From: Simon Davis
Sent: 04 January 2019 14:17
To: Planning.Responses
Subject: FW: A18237C. Kings Beach Hotel (P/83/18/DOC)

Further Drainage Engineer comments

From: Laura Gibbons
Sent: 04 January 2019 14:15
To: 'Andy Johnson' [REDACTED]
Cc: 'Tom Hall' [REDACTED] Simon Davis [REDACTED]
Subject: RE: A18237C. Kings Beach Hotel (P/83/18/DOC)

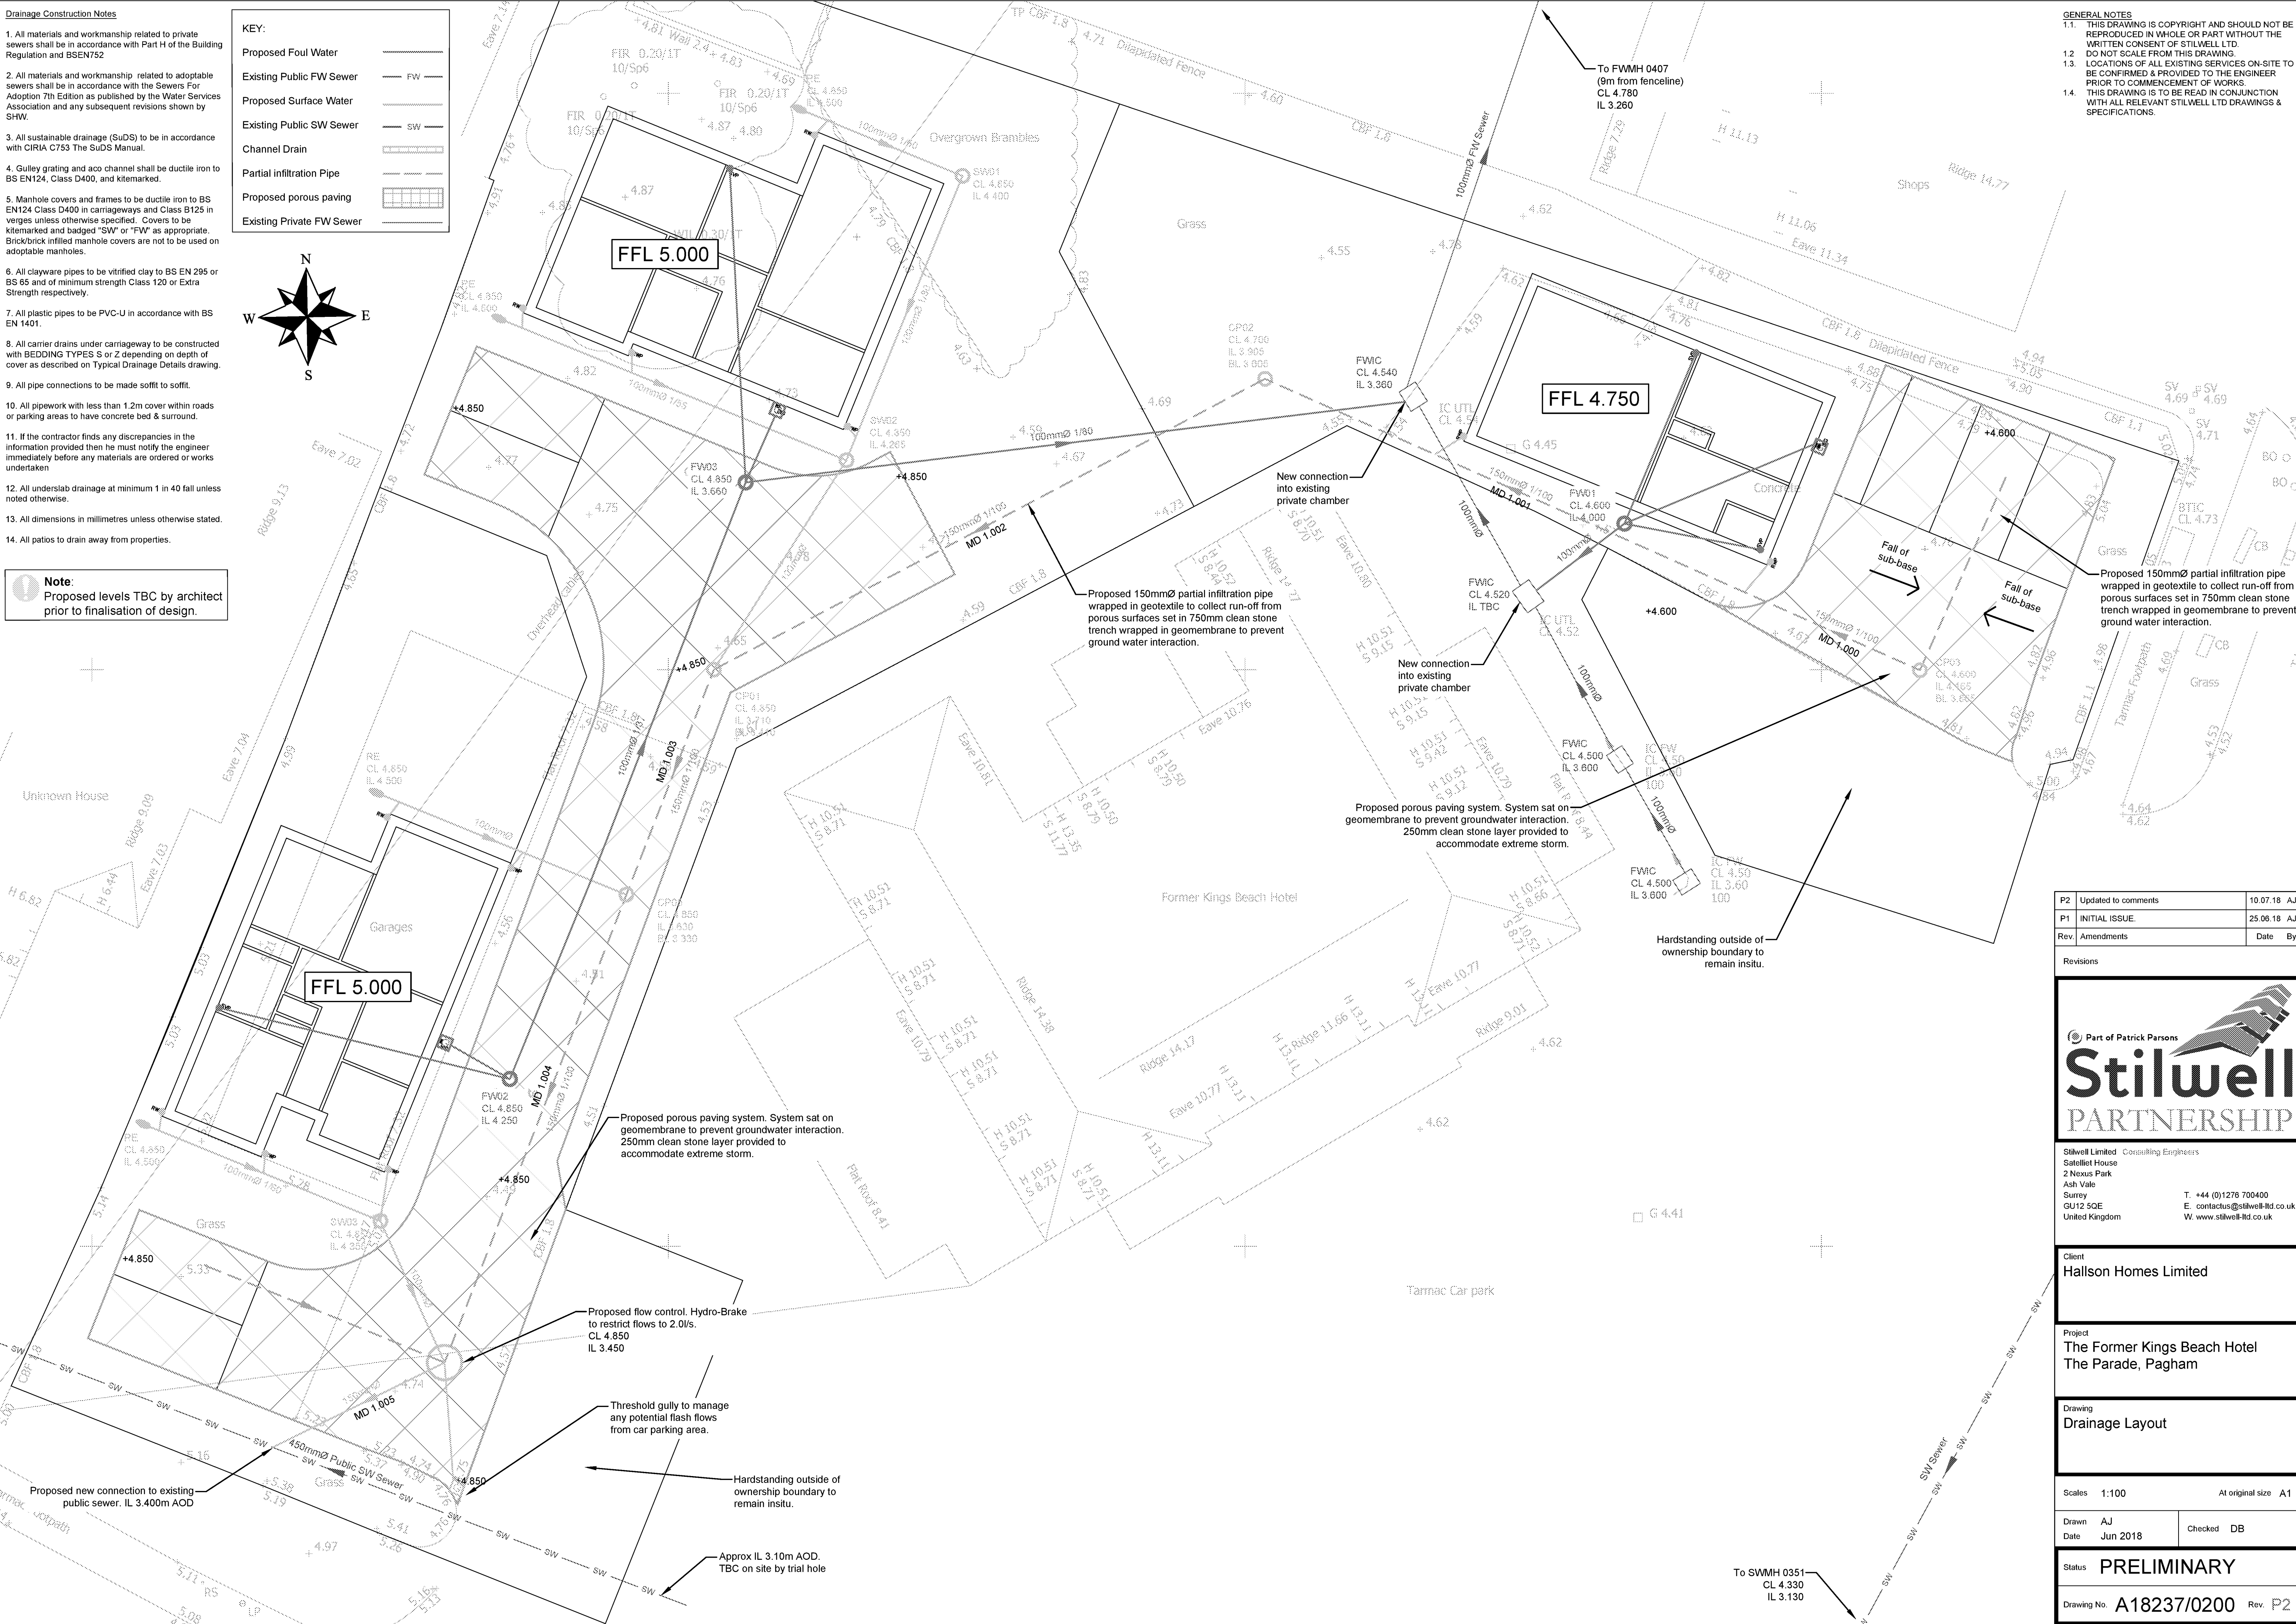
I do need to see the finish and formation levels specified on the layout plan too.

The calculations do not stipulate the capped depth of stone you state, you have only got invert and cover depths for the storage features. The difference between these is not equal to the depth of stone you stipulate, nor is there any other differentiation between void ratios of the various layers above the stone.

The stone depth required needs to equal or exceed the maximum water depth modelled. Either you model the invert and cover depths so that the difference is equal to the stone you propose, or you model total formation depths and take the maximum water depth calculated as the depth of stone required.

As a further check (which may help demonstrate my point) please ensure the free volume within the stone sub base is equal to or greater than the maximum water volume. If as you state in the eastern catchment you have 250mm of stone, free volume is $10*9*0.3*0.25=6.75 \text{ m}^3$, this is less than the maximum volume of water of 10.4 m^3 .

Therefore, the depth of stone needs to be increased.

The dimensions you noted are the overall construction depth. This allows for the topping and sand blinding, the input stone depth in MicroDrainage is capped at 250/350 as required.
